DECISION DELEGATED TO DEVELOPMENT MANAGER

Application No: H16-0430-20 **Applicant:** Mr I Bird

Proposal: Re-development of site to comprise 5 flats, 2 single storey dwellings and 1 1.5 storey dwelling.

Location: 59 Westlode Street Spalding

title
PROPOSED ELEVATIONS UNITS 1 - 8

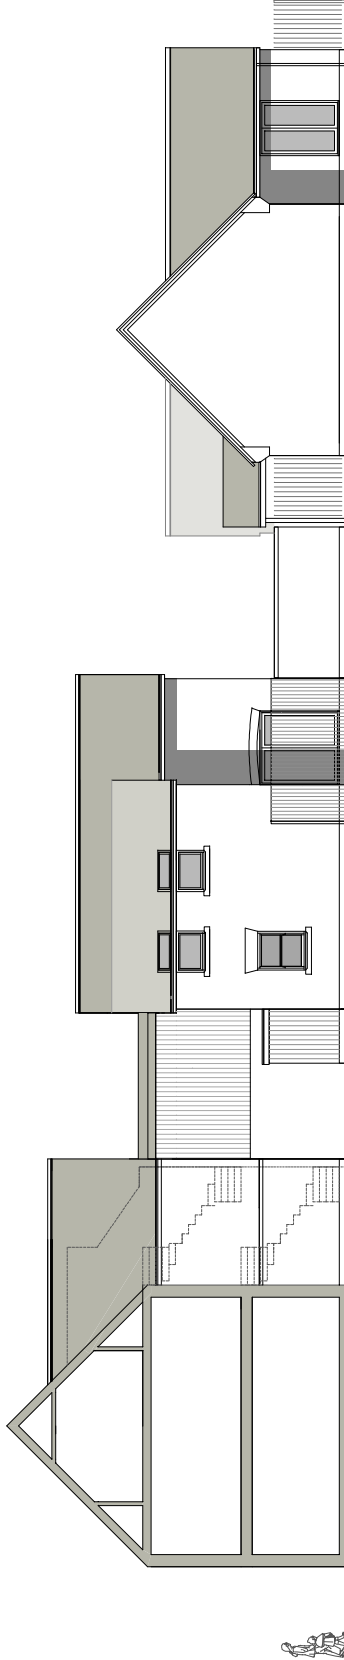
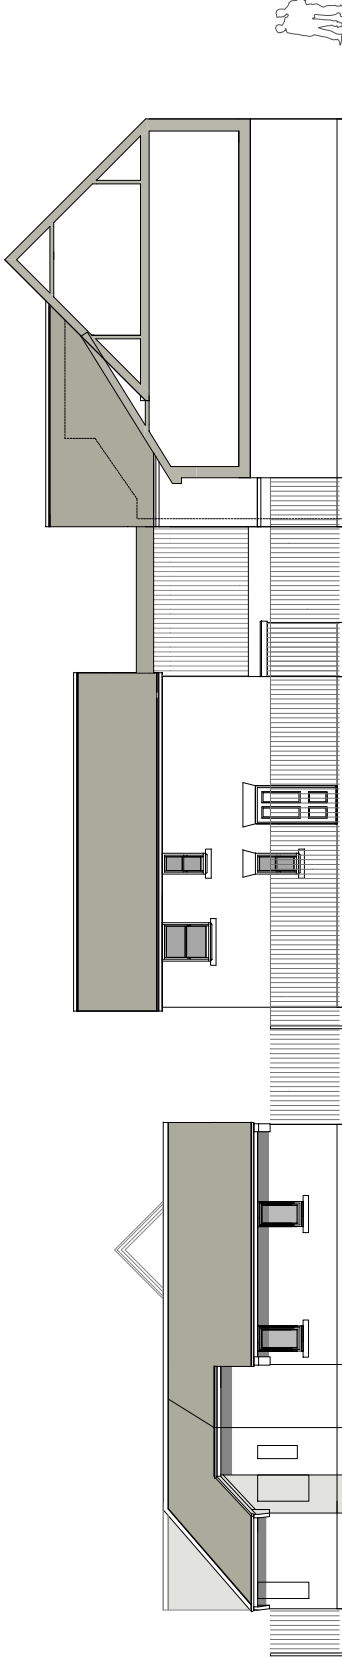
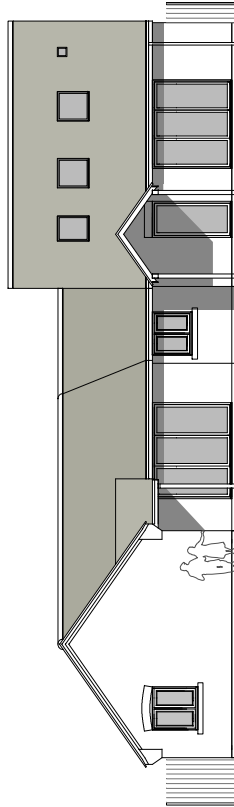
Furthermore, as the surrounding properties are 2 storey in scale and encroach upon the land significantly, it is suggested that the proposal would play host to a number of residential properties which are themselves overlooked to an unacceptable degree by the existing neighbouring residences, particular concern is raised over the proposed unit 8, for which the amenity space would be directly overlooked by the rear of 33 Double Street.
